Erection of 1 No. two-bedroomed detached bungalow. This application is a Departure from the Development Plan.

Land adjacent to Pindars Lyminster Road Lyminster

Thank you for your internet representation made on 22nd April 2018 which has been recorded as '**an objection**' with the comments as follows:

DRAWING PLANNING DATE: JANUARY 2018 DRAWN: T. Murray	SCALE 1/50
DRAWING: 18/04/2	REVISION:

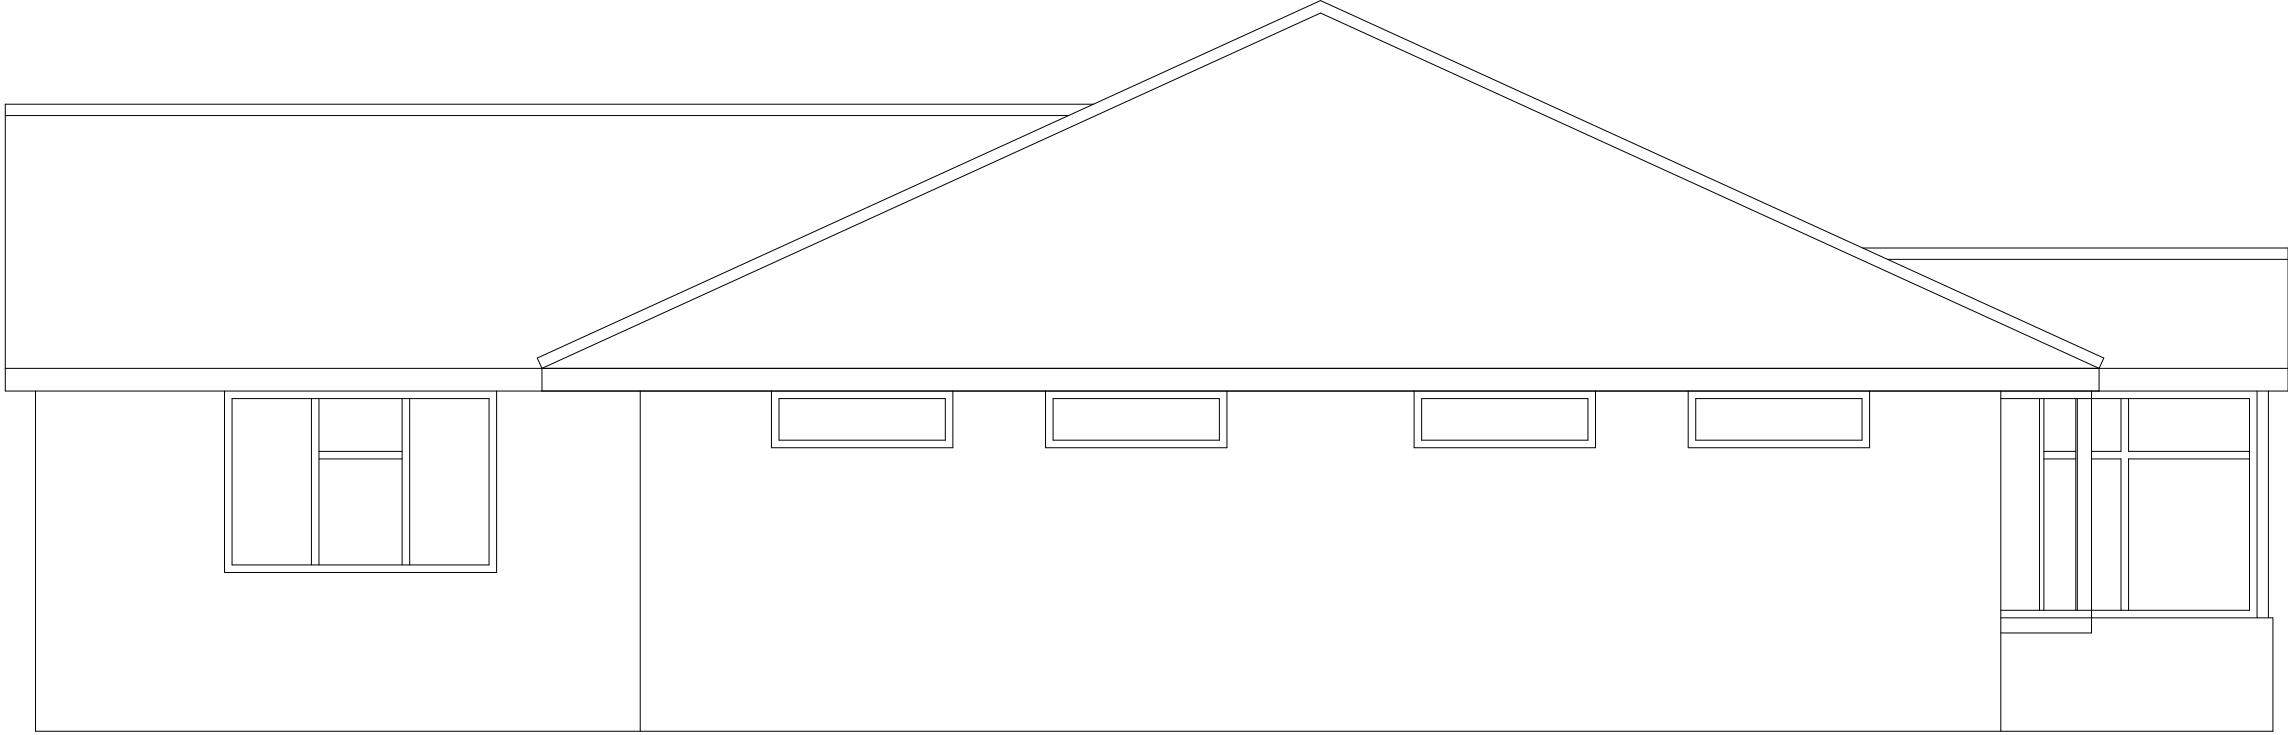
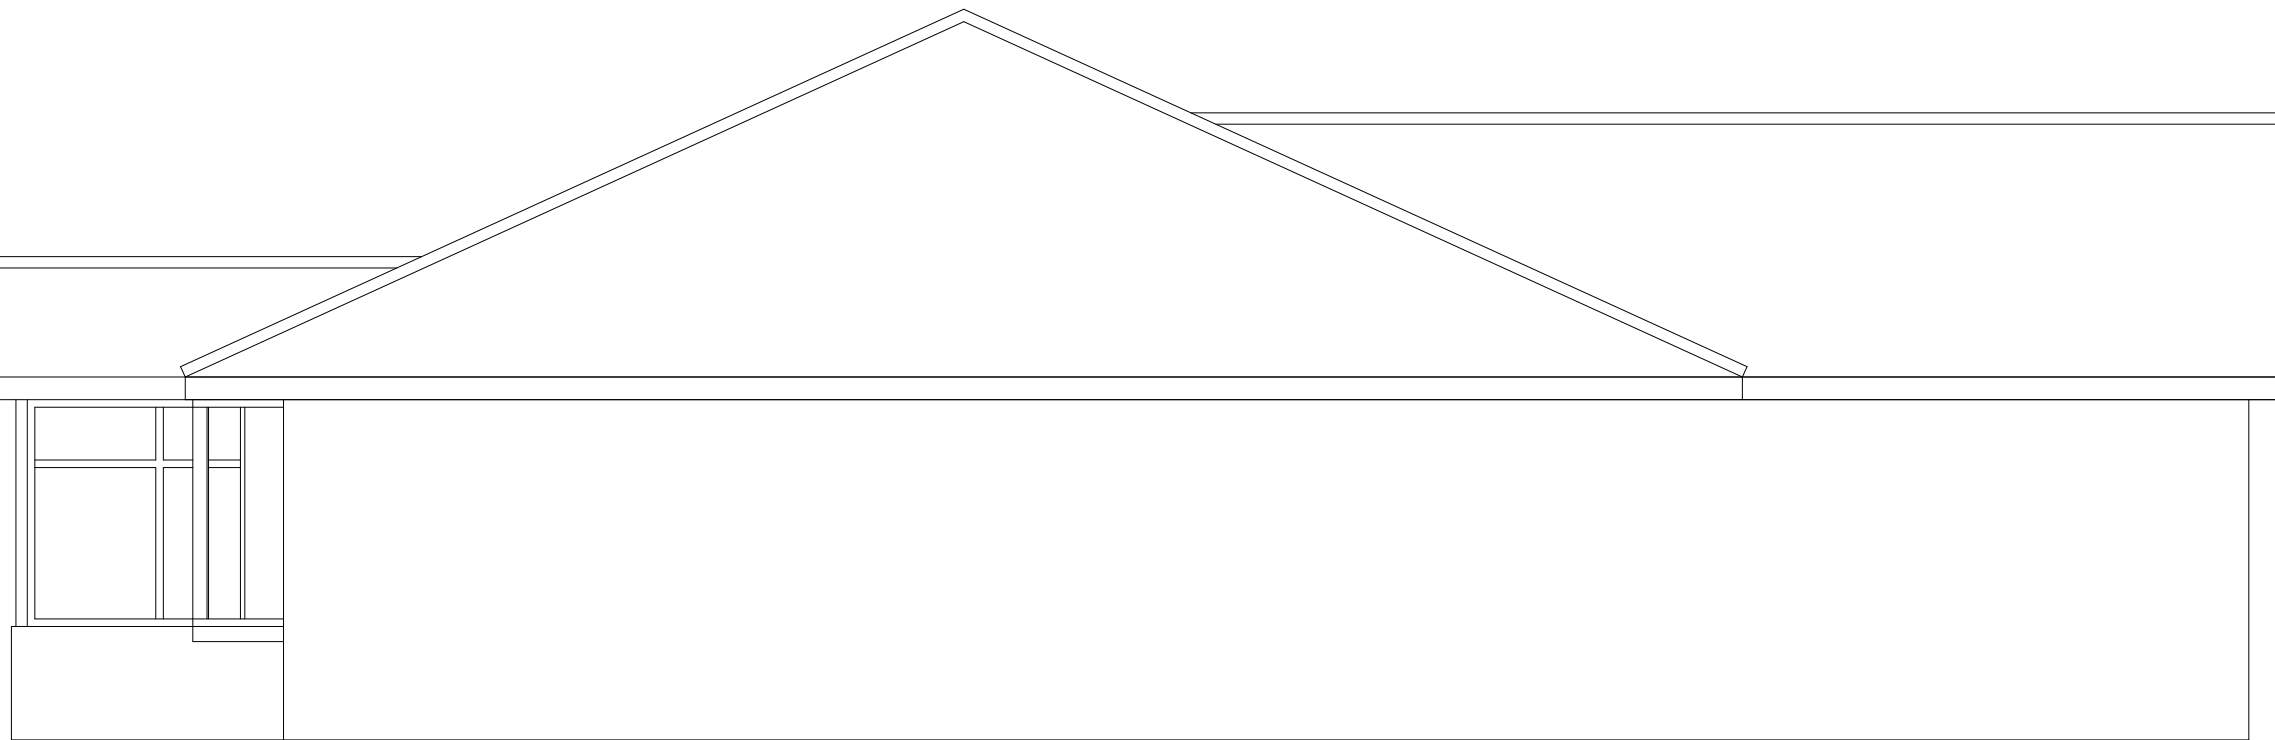
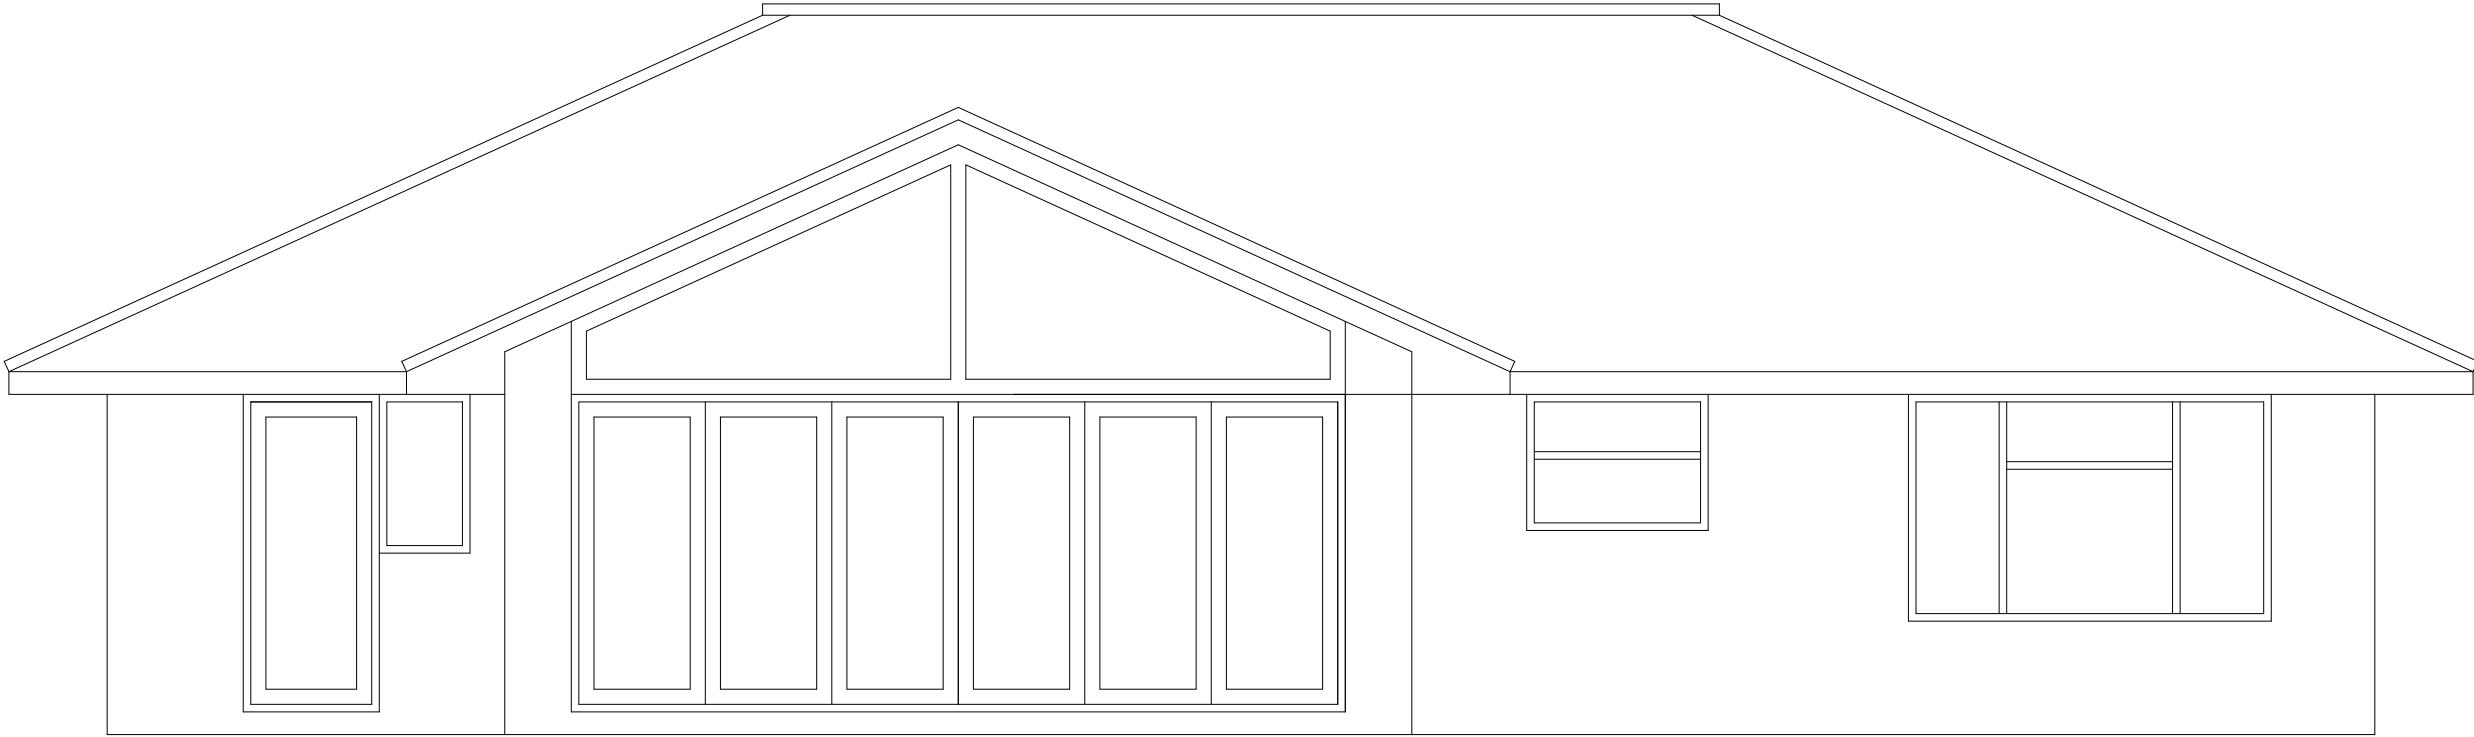
A reduction in the footprint of the proposed building, especially the width, would enable the building to be moved closer to the road and align with the existing Pindars property whilst still leaving ample parking in front of the existing Pindars dwelling and the new building. This reduction in the width of the property would mean the pitched roof could be reduced in height. This combined with the northward movement of the new building would result in the structure would be less obtrusive from the adjoining Bay Tree House's garden.

DRAWING	SCALE
STREET SCENE	1/100
DATE:	JANUARY 2018
DRAWN:	T. Murray
DRAWING: 18/04/6	REVISION:

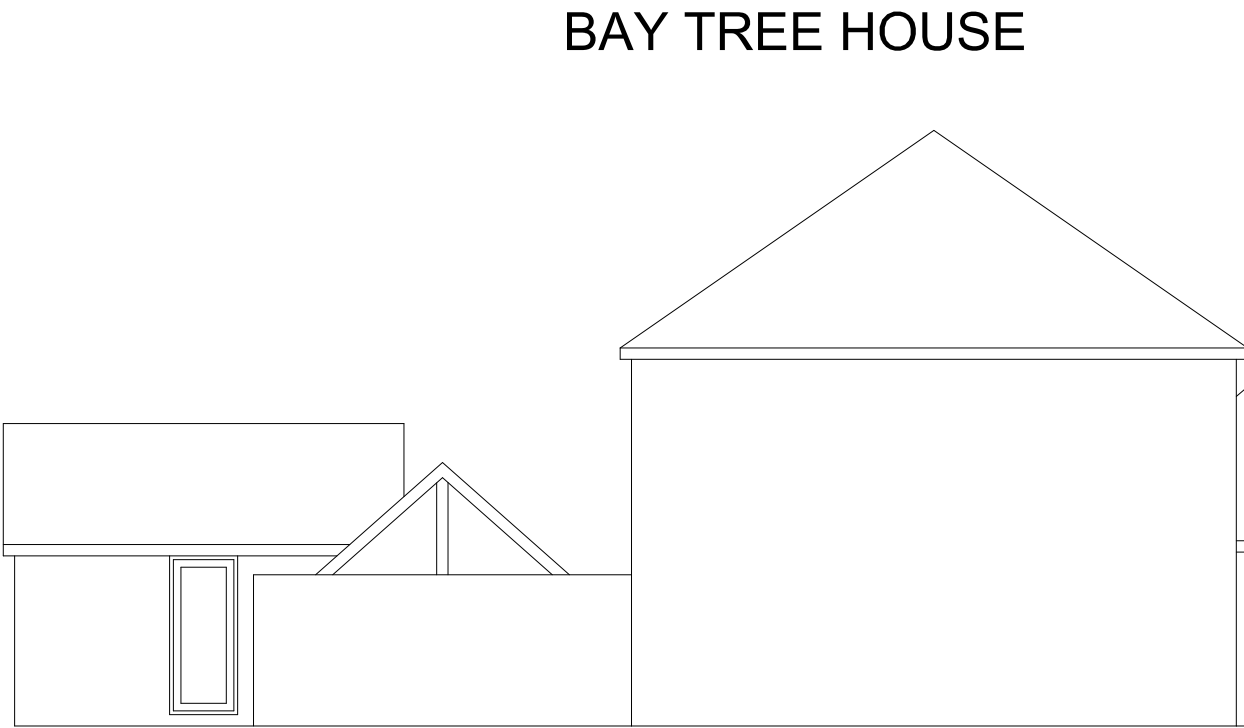
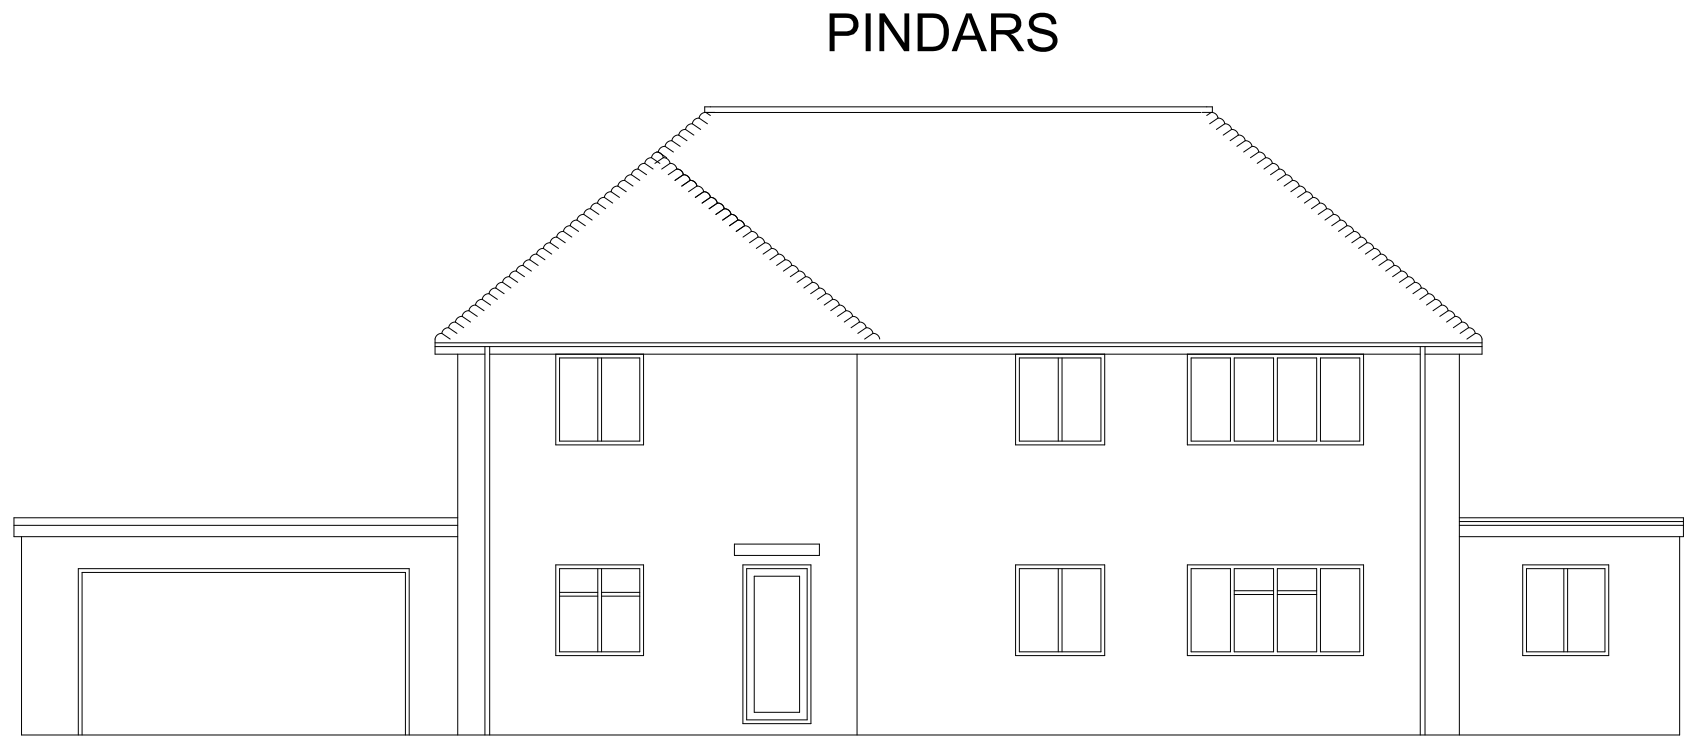
The submitted elevation drawing is misleading as it shows all three properties on the same level. This is not correct as the Existing property is around a meter higher than the Bay Tree Buildings and the proposed new build would be at the same base height as the existing building unless the bank of soil is removed.

The elevation drawings do however indicate the relative heights of the proposed new building that is significantly higher than the Bay Tree Annex.

DRAWING PROPOSED SITE PLAN DATE: JANUARY 2018 DRAWN: T. Murray	SCALE 1/500
DRAWING: 18/04/4	REVISION:

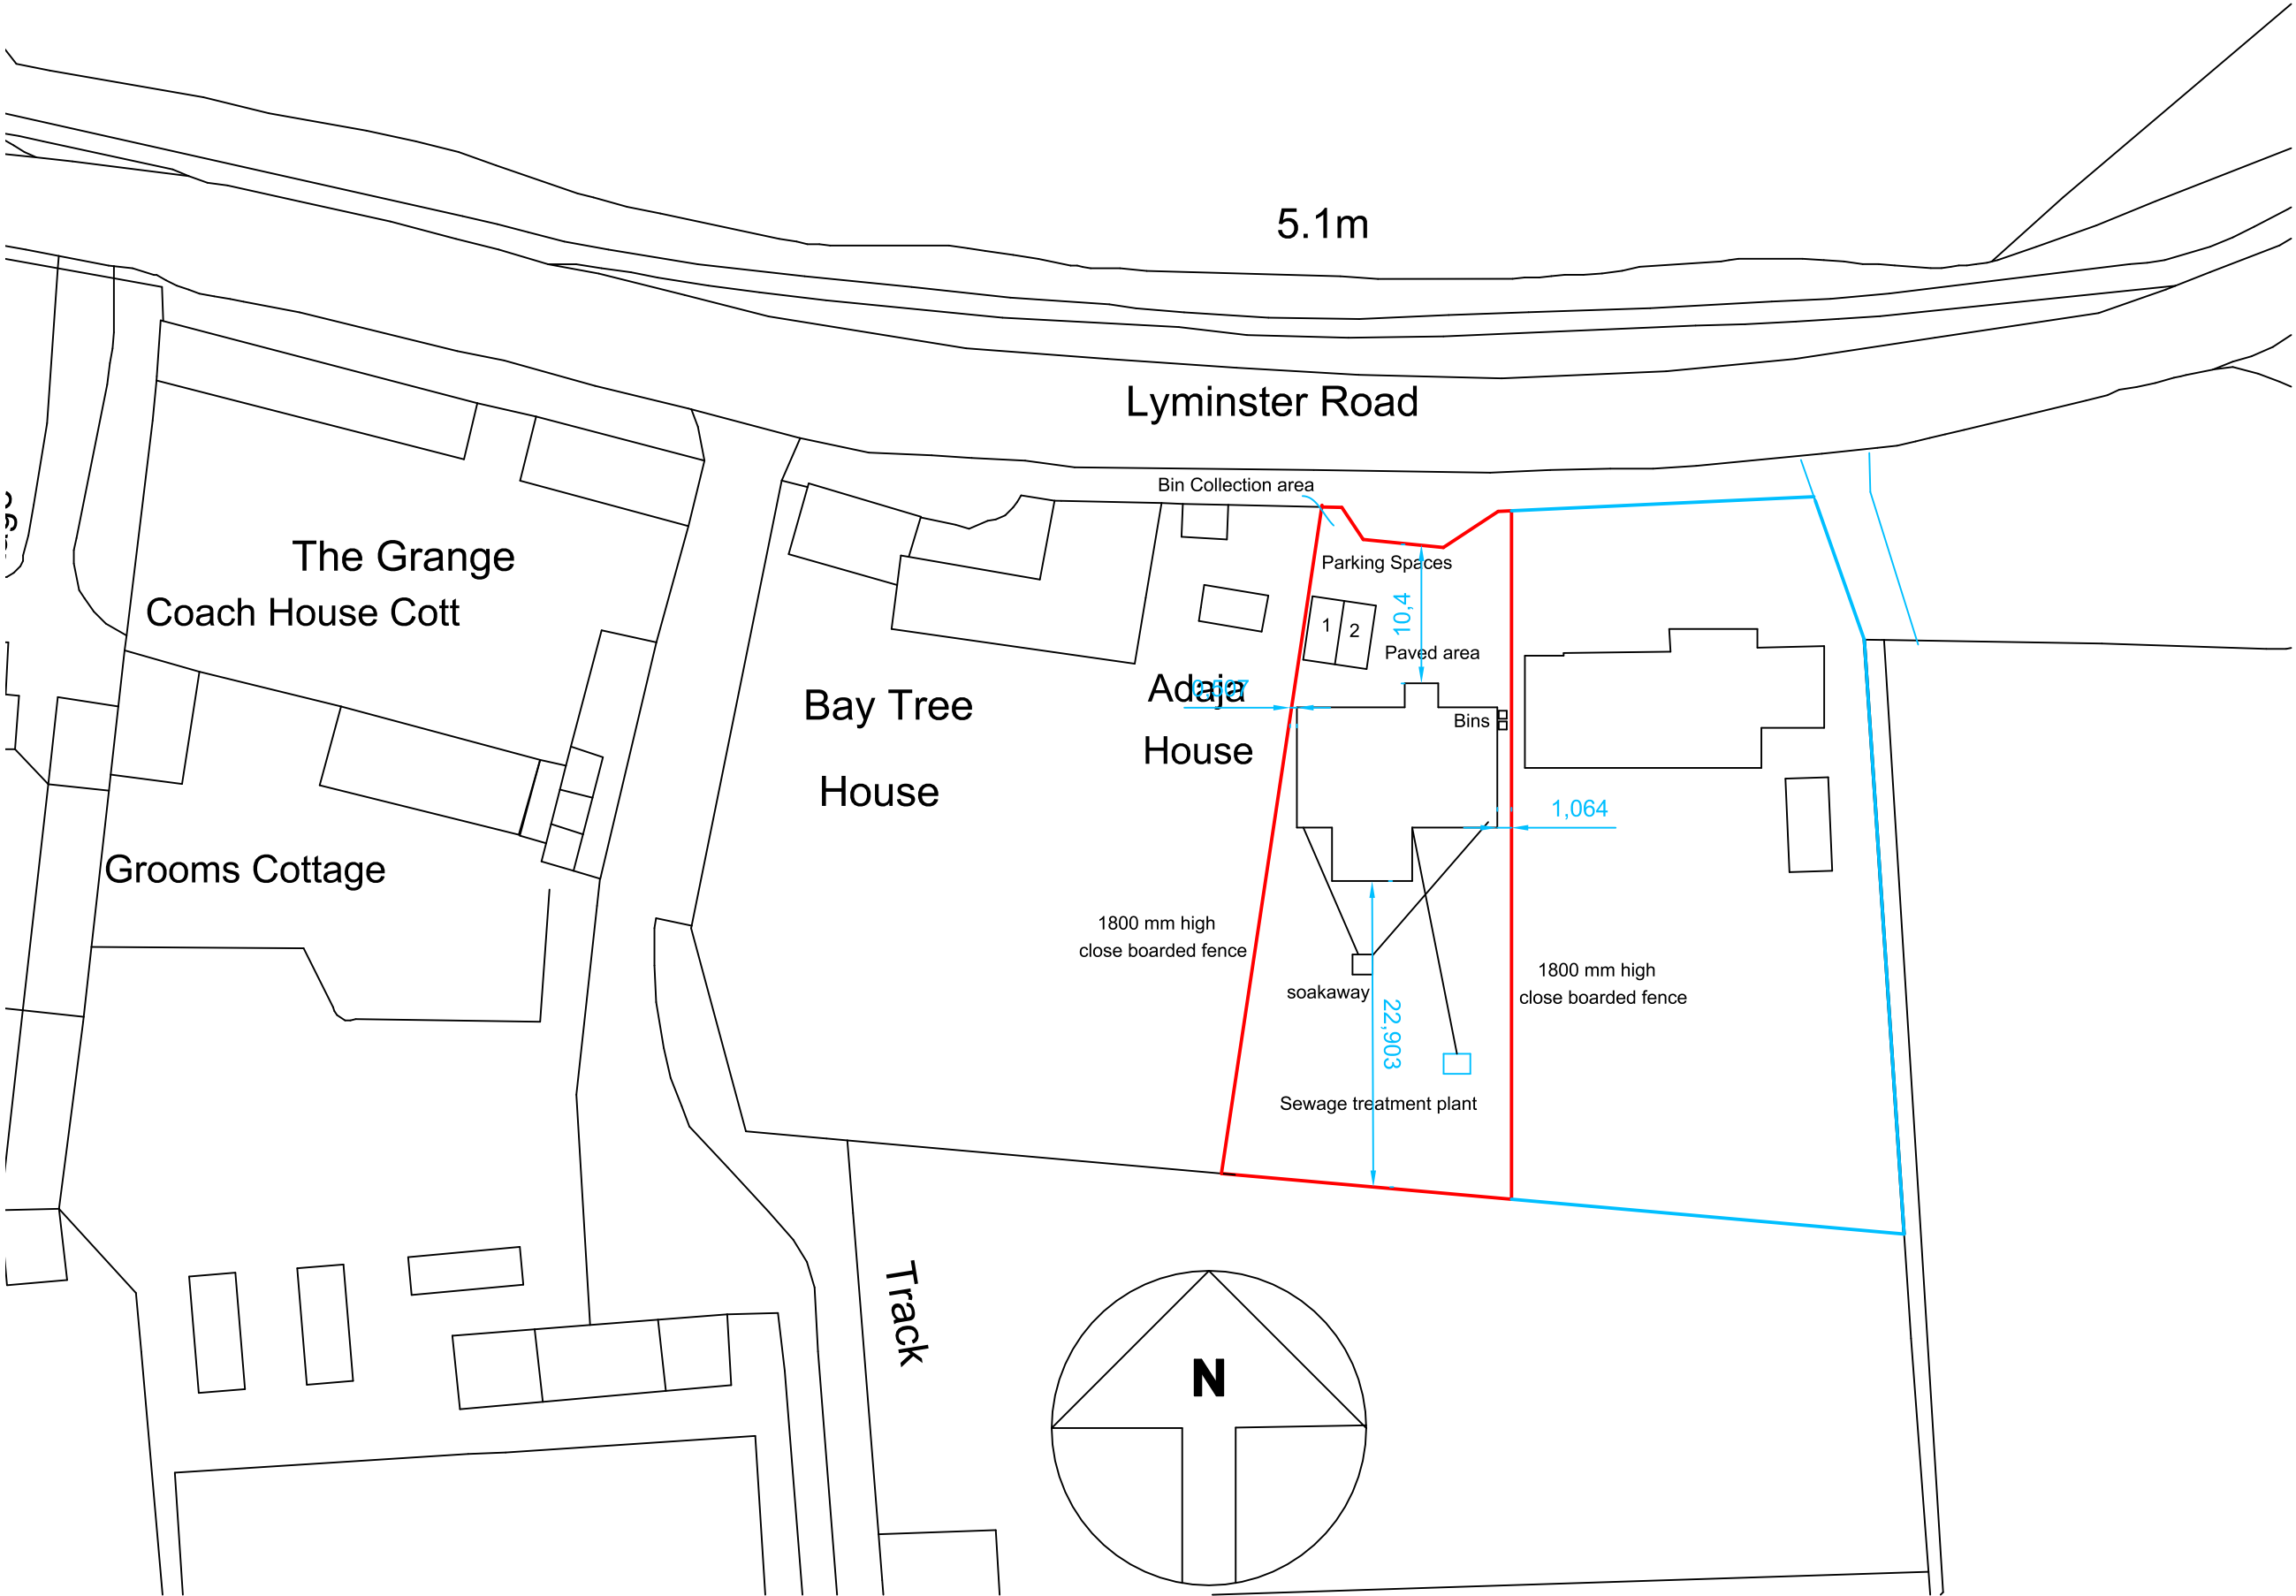
Biodiversity Form indicates no loss of hedges etc but the Design and Access Statement document proposes removal of the west boundary hedge. In recent months a significant size privet hedge and several trees have been taken out so making it important to conserve the Holly hedge.

In fact this 50 year old holly hedge boundary belongs to the adjacent property (Bay Tree House) and there is no such proposal or agreement to remove this holly hedge that provides shelter, food and nesting opportunities for small birds.
